**WEST SUSSEX COUNTY COUNCIL
STRATEGIC PLANNING CONSULTATION**

SUBJECT: FP/12/17/PL- 1 No. dwelling (resubmission following FP/113/16/PL).

Plot to the rear of Starry Nook, Sea Road, Felpham, PO22 7AW

PLAN (Proposed & Existing)

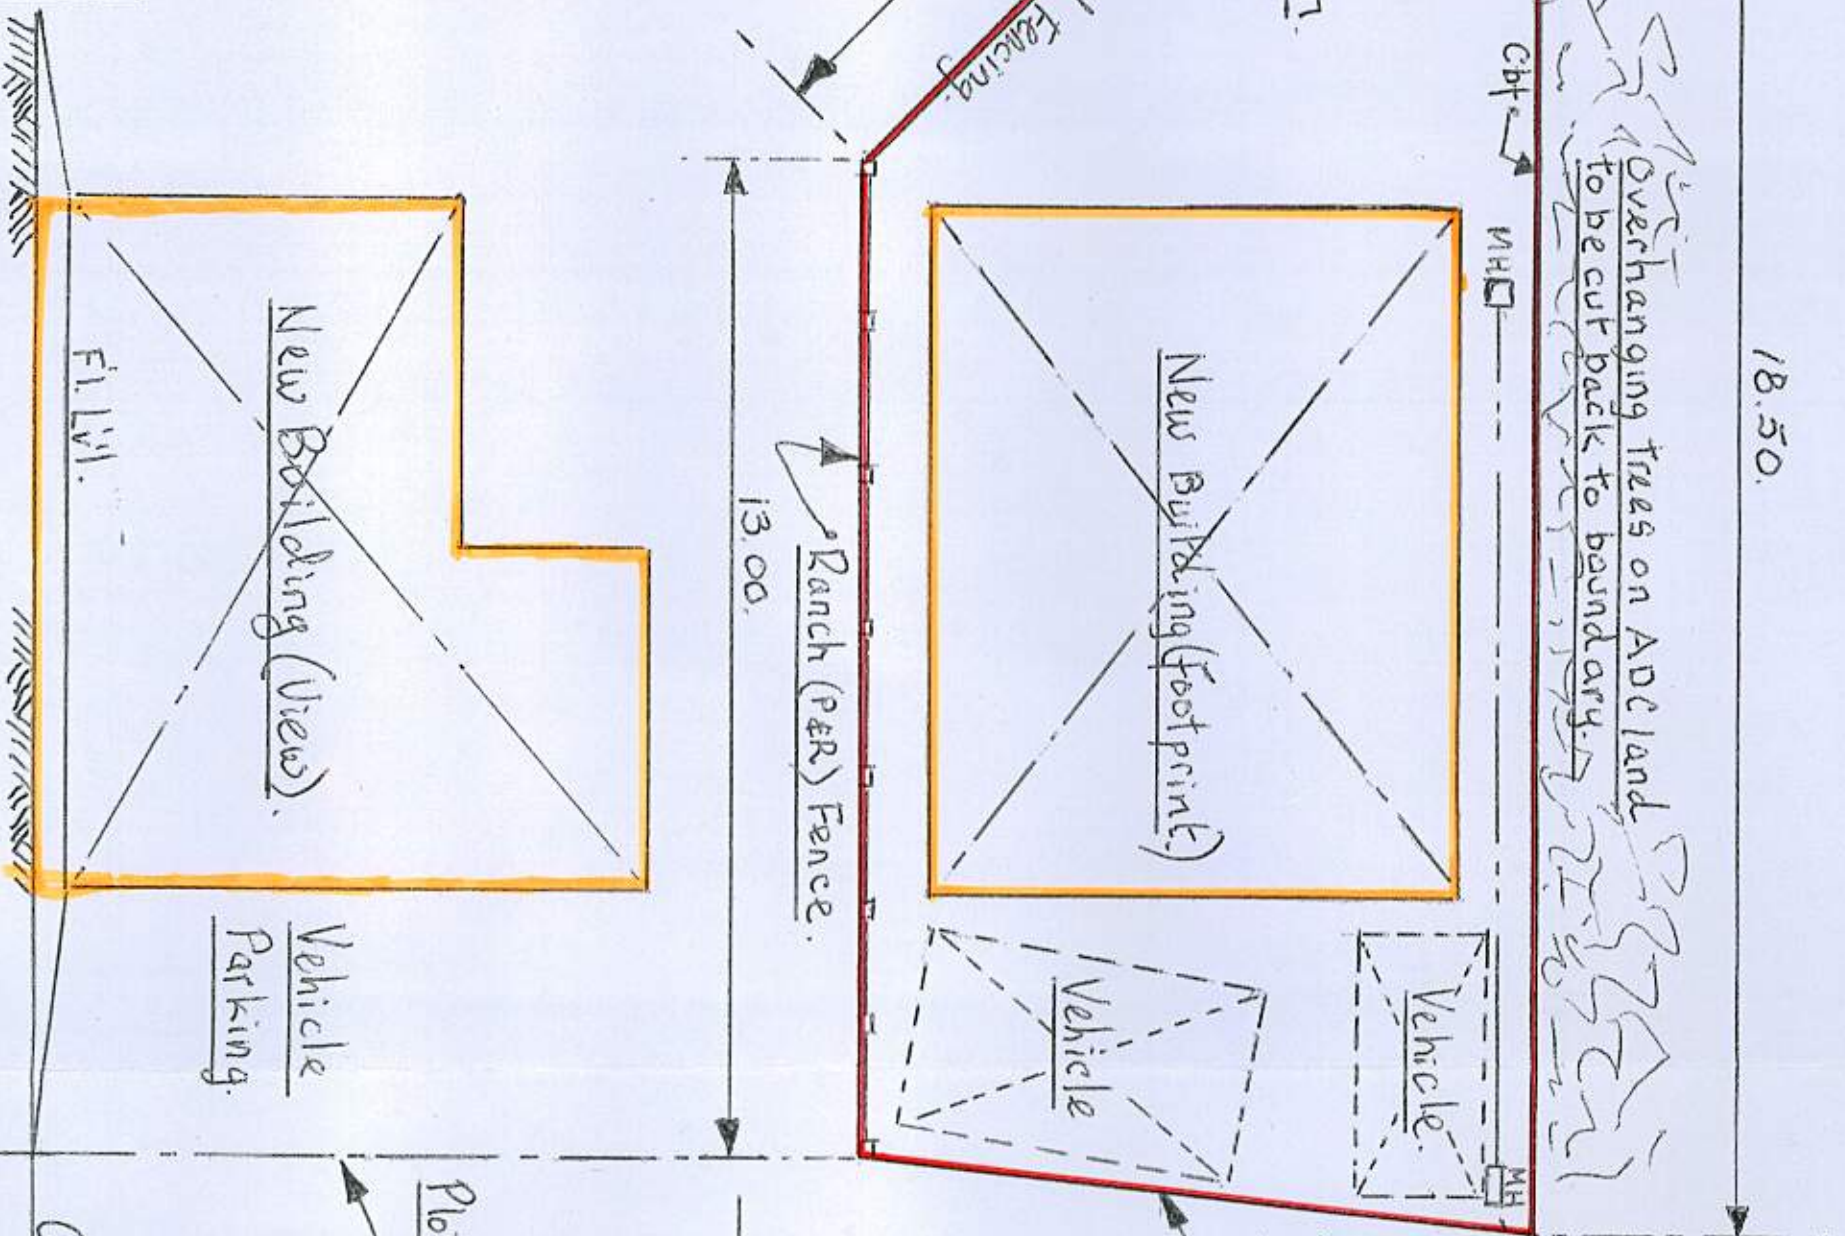
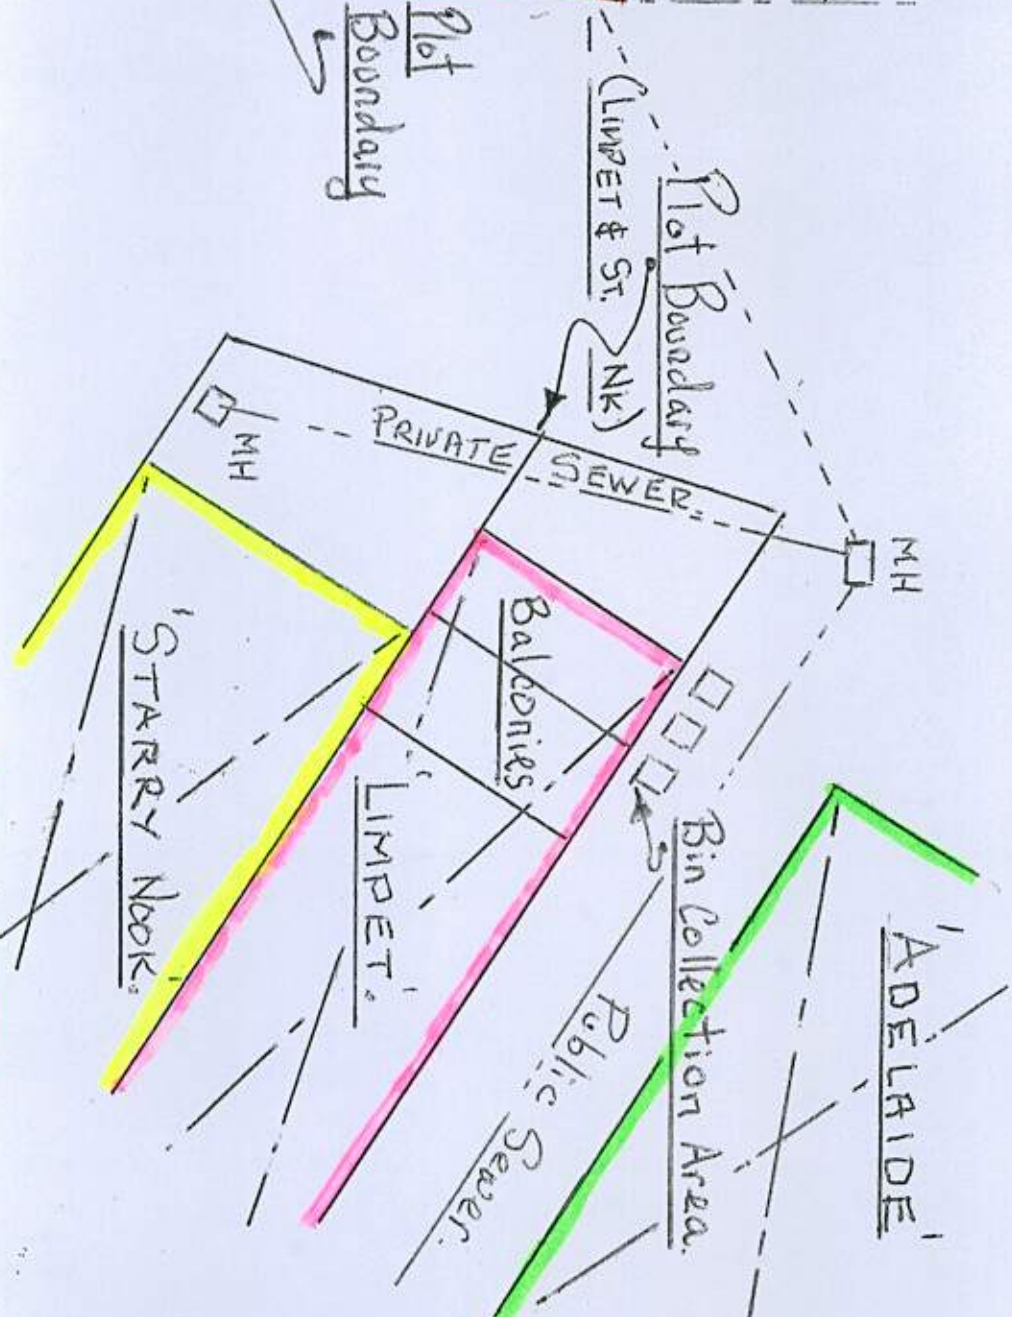
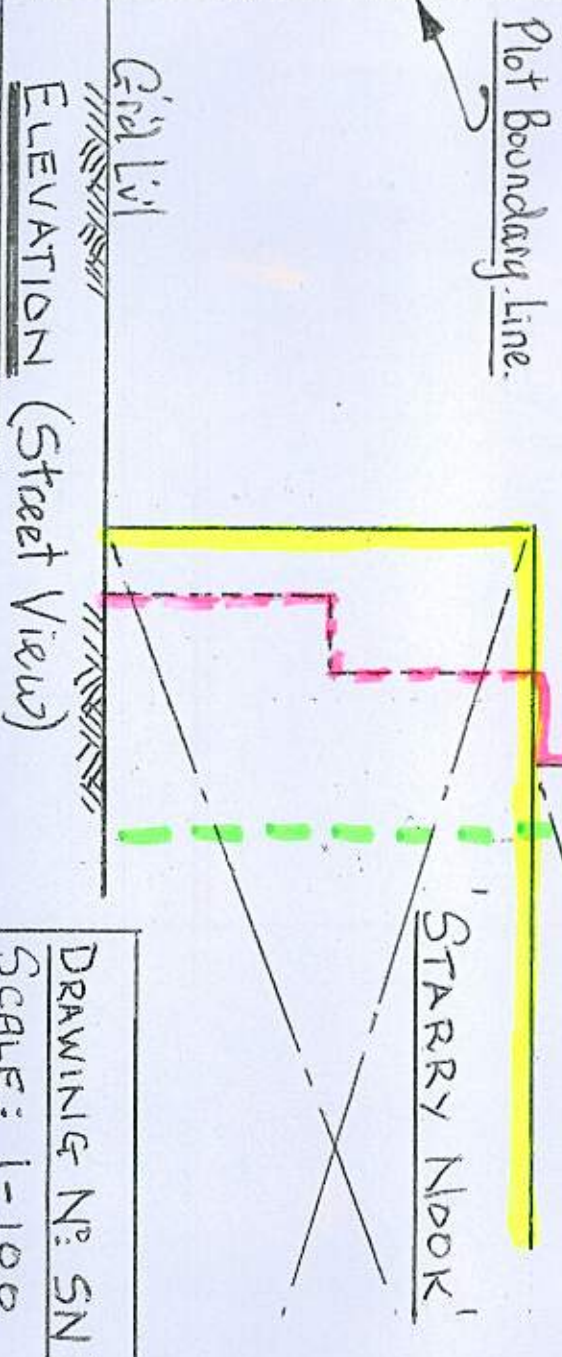
The access arrangements do not appear to have been altered since the previous application.

Three parking spaces are to be provided alongside the 2 bedroom dwelling, this is considered sufficient. Cycle parking should be conditioned alongside any consent of this application to encourage more sustainable travel alternatives.

Visibility appears sufficient from the privately maintained Longbrook onto Sea Road, junction protection serves to ensure vehicles will not obscure the access.

Block plan 1 : 500

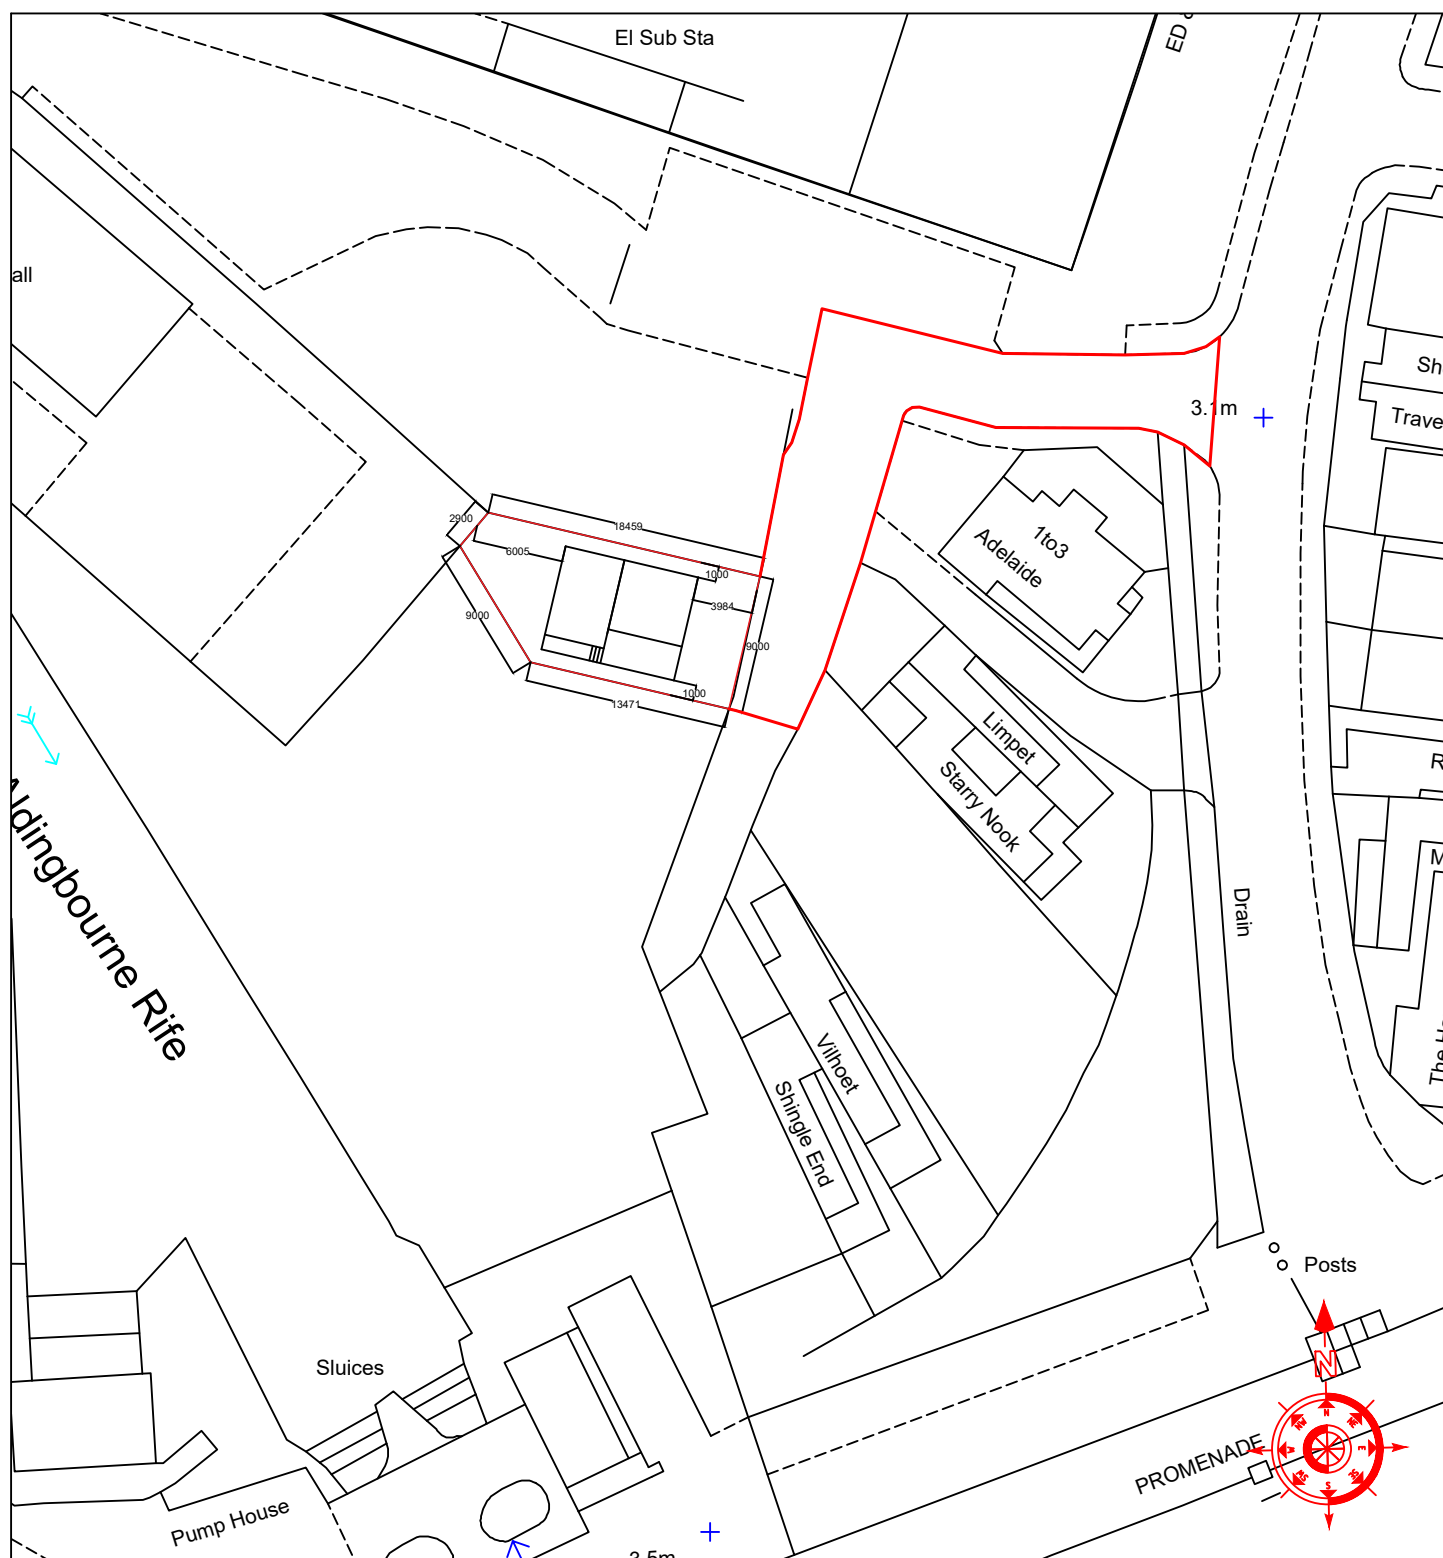
The Proprietor of Longbrook should be contacted in order to gain permission to use this land for the proposal.
